Project #: 1003372 Application #: 12DRB-70173
Project Name: North Albuquerque Acres Tract A Unit B
Agent: RBA Architects L Phone #:

**CITY OF ALBUQUERQUE
PLANNING DEPARTMENT
July 25, 2012
DRB Comments**

**RE: Lot 30-A-3,, Block 11, Tract A Unit B, North
Albuquerque Acres**

12DRB-70173 MAJOR – SITE DEVELOPMENT PLAN FOR BUILDING PERMIT

**1 SITE PLAN**  
 1"=10'-0"  
 BAR SCALE  
 0 10 20  
 (IN FEET)

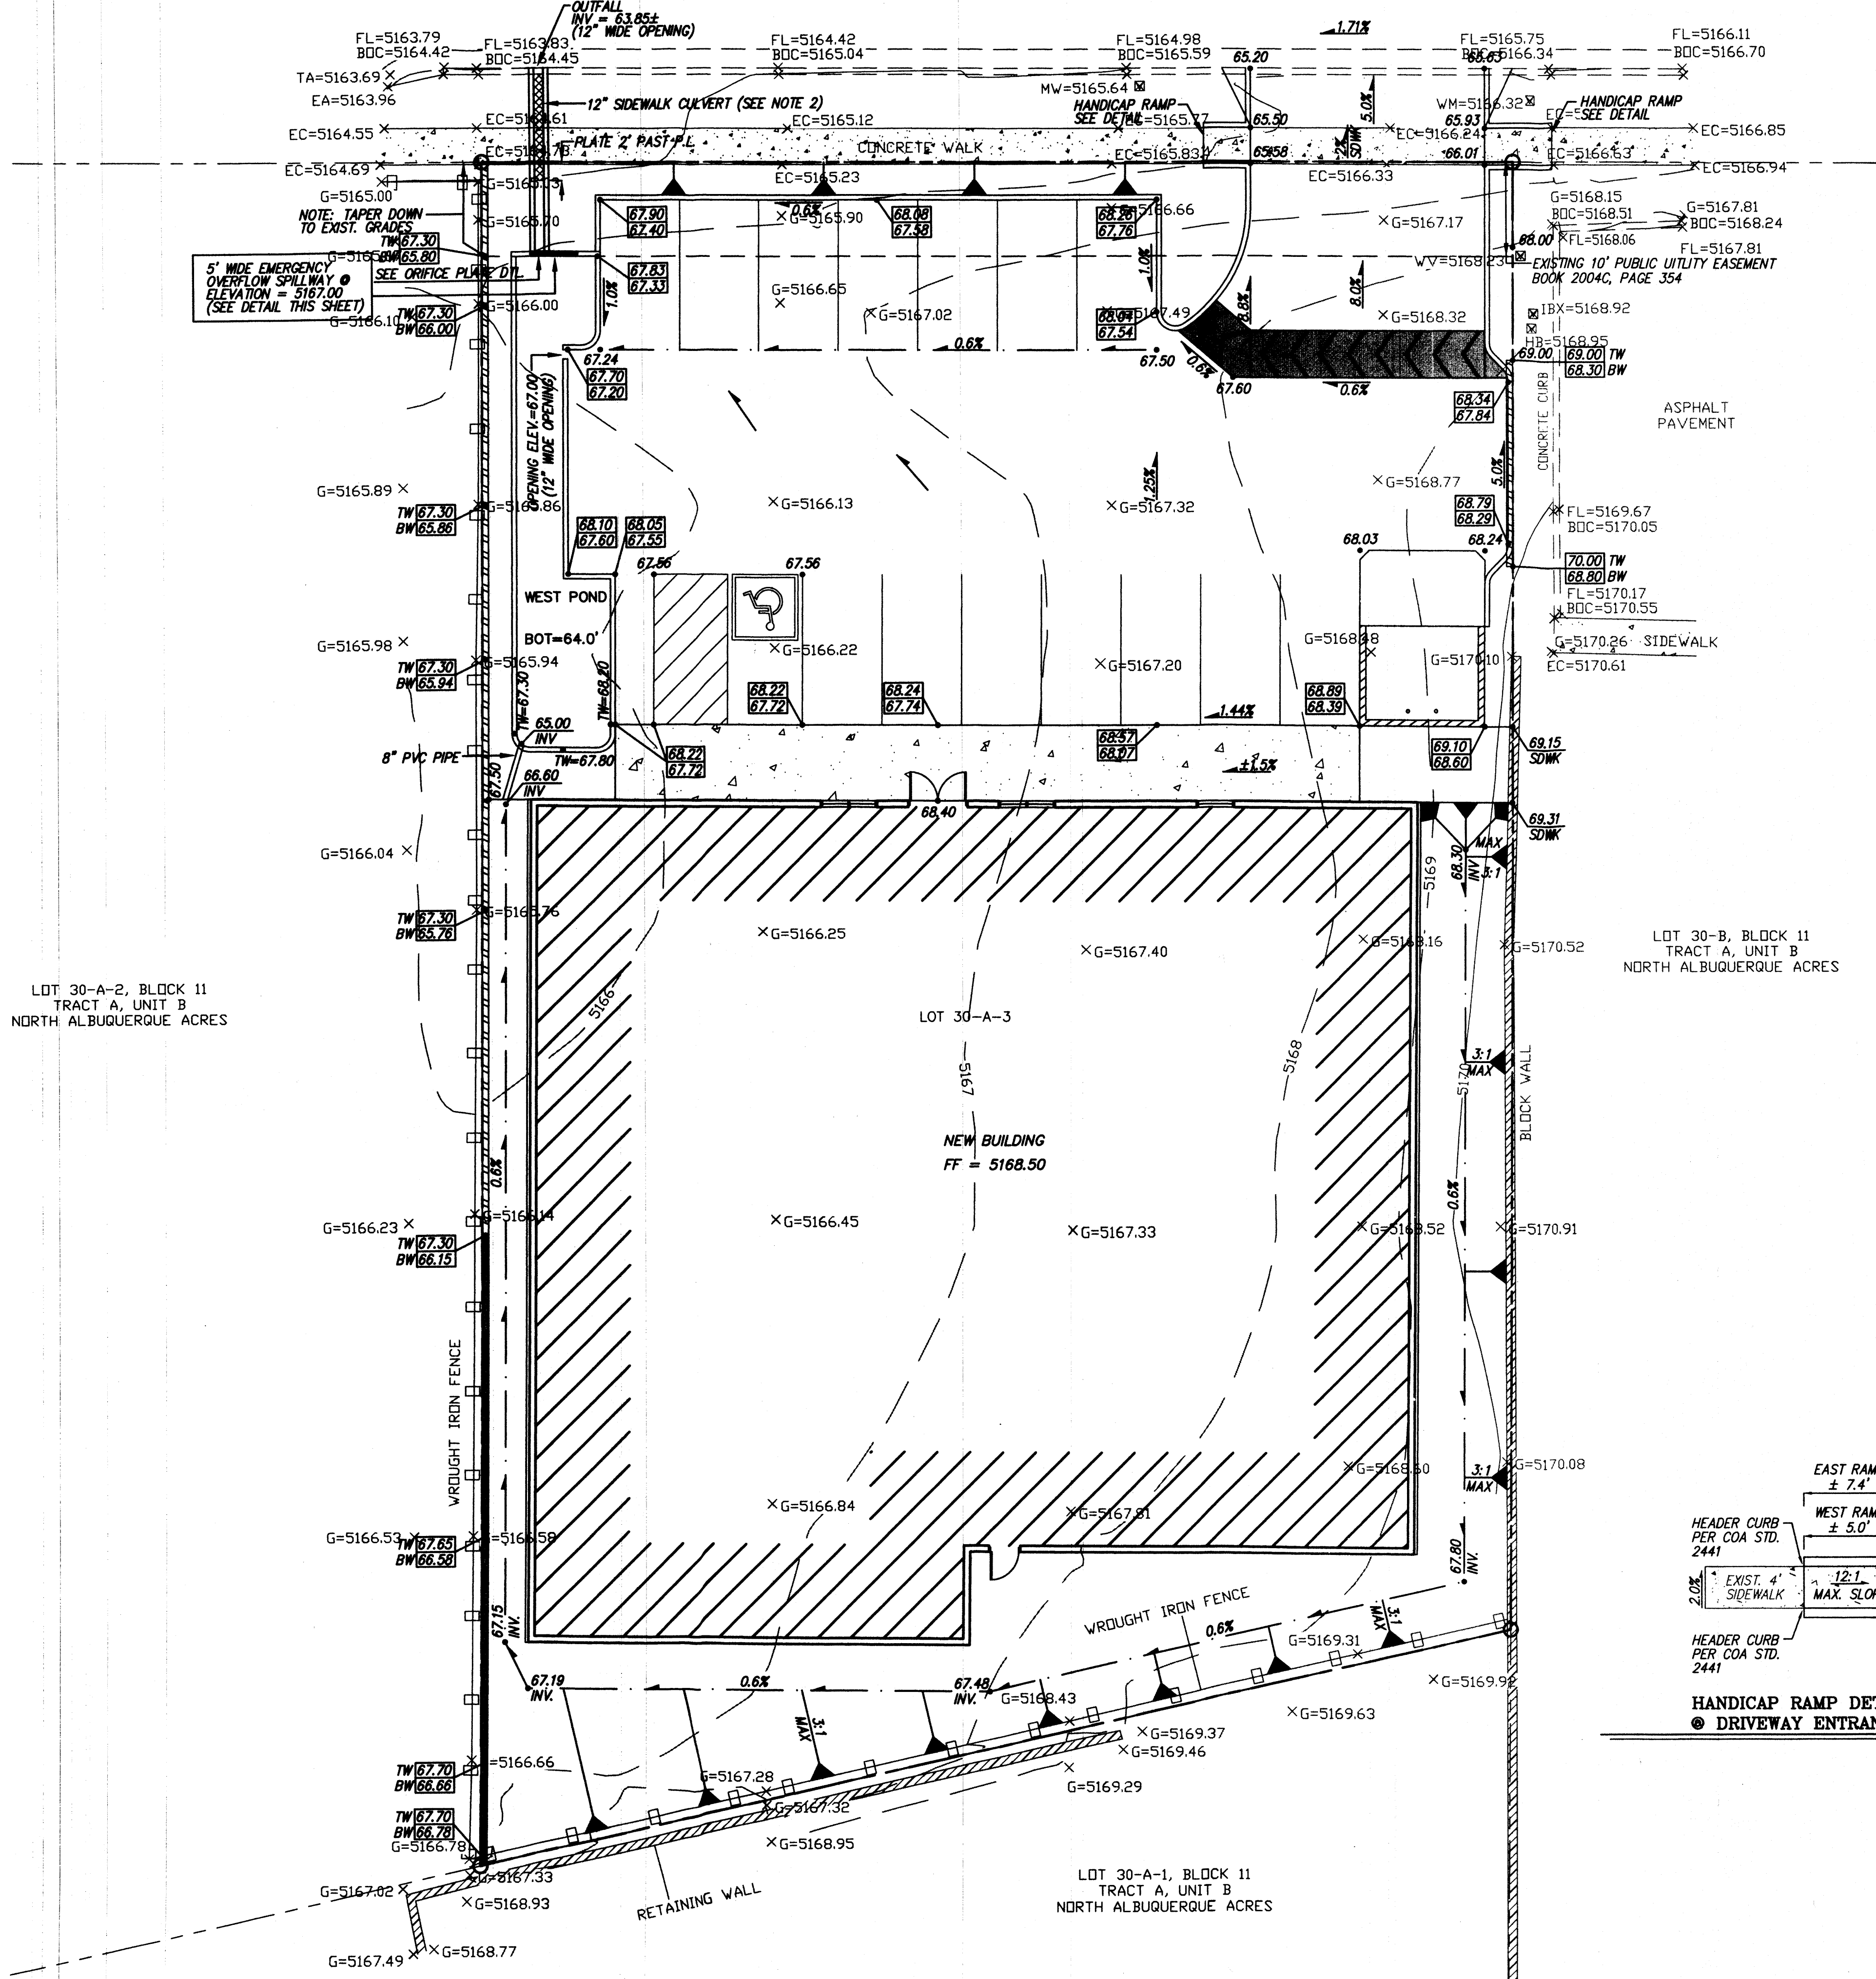
AMAFCA No comments
COG No comments provided
TRANSIT No comments provided
ZONING ENFORCEMENT What zoning is being used; the 1986 or the 2010 Zoning must be shown. Provide elevations views-must comply with the design guidelines in the 2010 North I-25 Plan. A pedestrian entrance to the site must be shown as per Page 32 e). The desert willows shown for street trees are considered to be accent trees. 2 of the three trees shown must be shade trees. 2 trees are required for the parking area-this cannot count the street trees for this purpose. The landscaping as shown does not have 75% ground coverage. Further review requires the elevations. Any signage planned needs to be shown.
NEIGHBORHOOD COORDINATION
APS This will have no adverse impacts to the APS district.
POLICE DEPARTMENT No Crime Prevention or CPTED comments concerning the proposed Site Development Plan for Building Permit request due to the lack of information available about property lighting, surveillance equipment.

1. Need to see building elevations. Site Plan states 3 story but no height is provided.
2. Lighting is not shown on the Site Plan. Lighting heights are restricted to 20' in this area and need to be noted on Site Development Plan.
3. SDP requirements for Landscaping buffer ???

**AMERICA'S PASTTIME  
 GRADING & DRAINAGE PLAN**

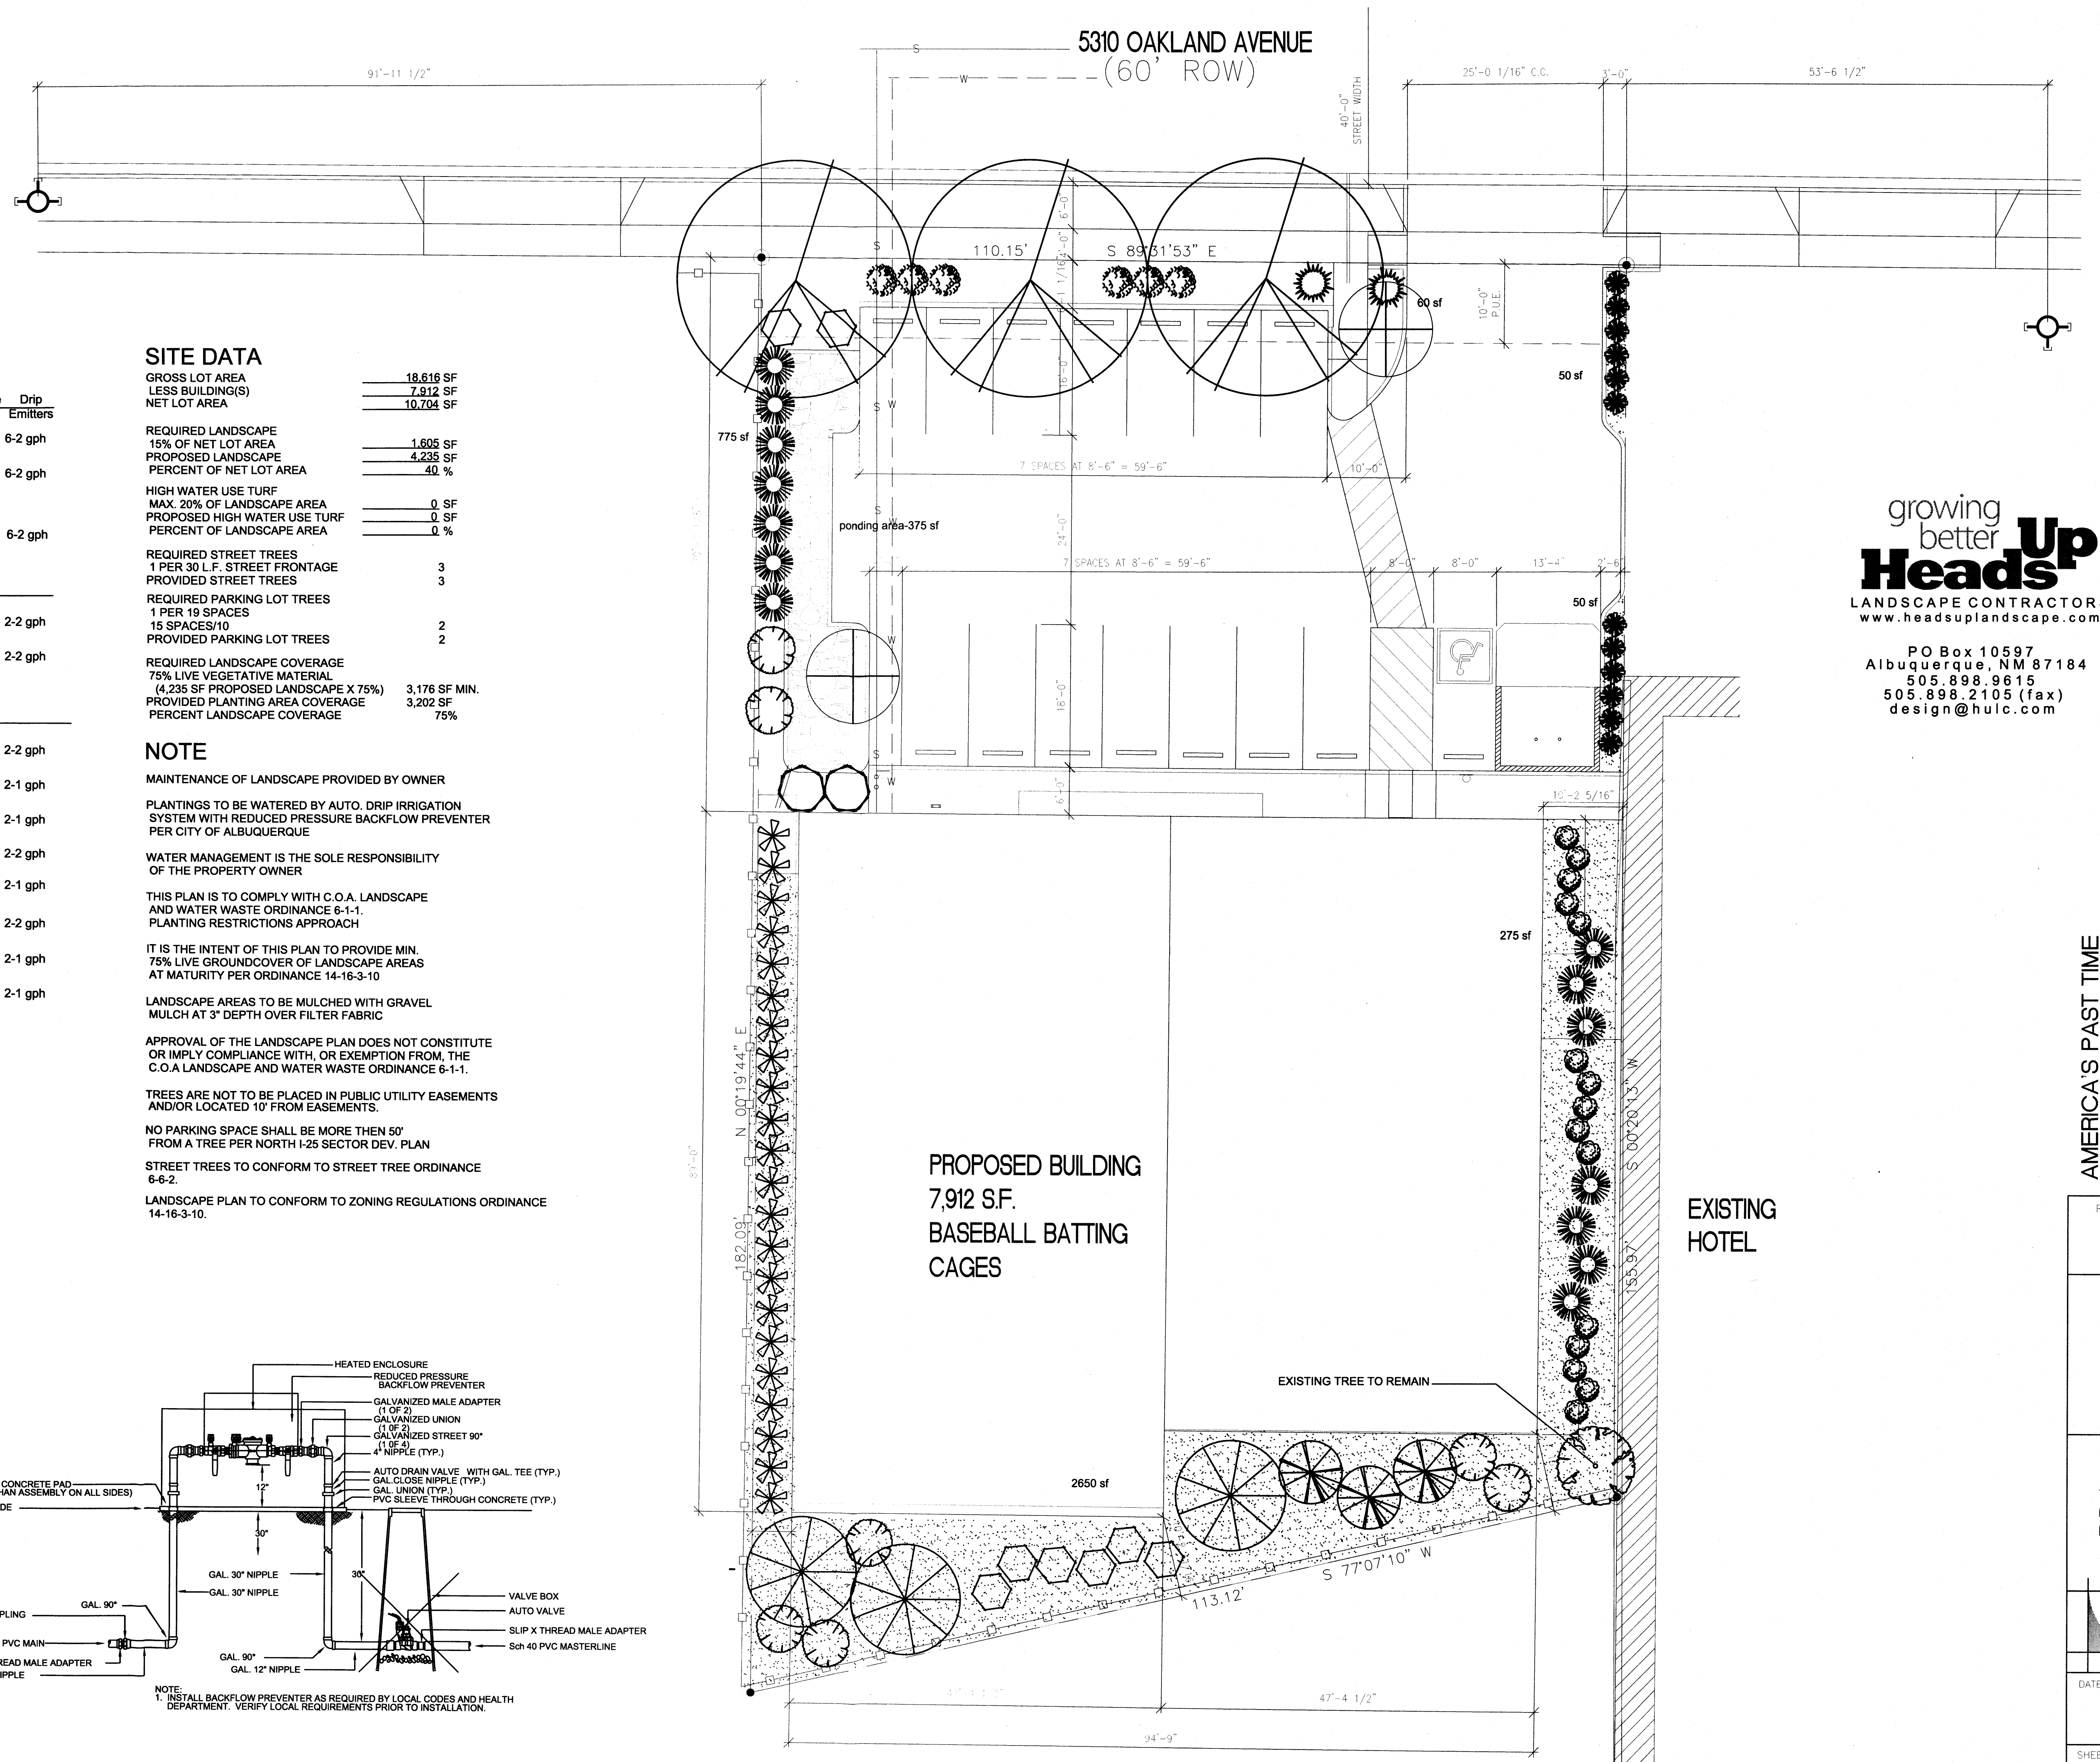
FIRE DEPARTMENT All site development plans for subdivisions and site development plans for building permit shall be submitted to the Fire Marshal's Office Plans Checking Division for review and approval.
PNM ELECTRIC & NMGAS No comments provided
COMCAST No comments provided
CenturyLink No comments provided
ENVIRONMENTAL HEALTH No comments provided
M.R.G.C.D No adverse comments
OPEN SPACE DIVISION Reviewed: No Adverse Comment
CITY ENGINEER Hydrology has not reviewed the latest grading and drainage plan submittal, however,

modifications, if any will probably be minor.

Since the pond has been moved out of the PUE, it would be preferable to have the newer grading and drainage plan in the Site Plan
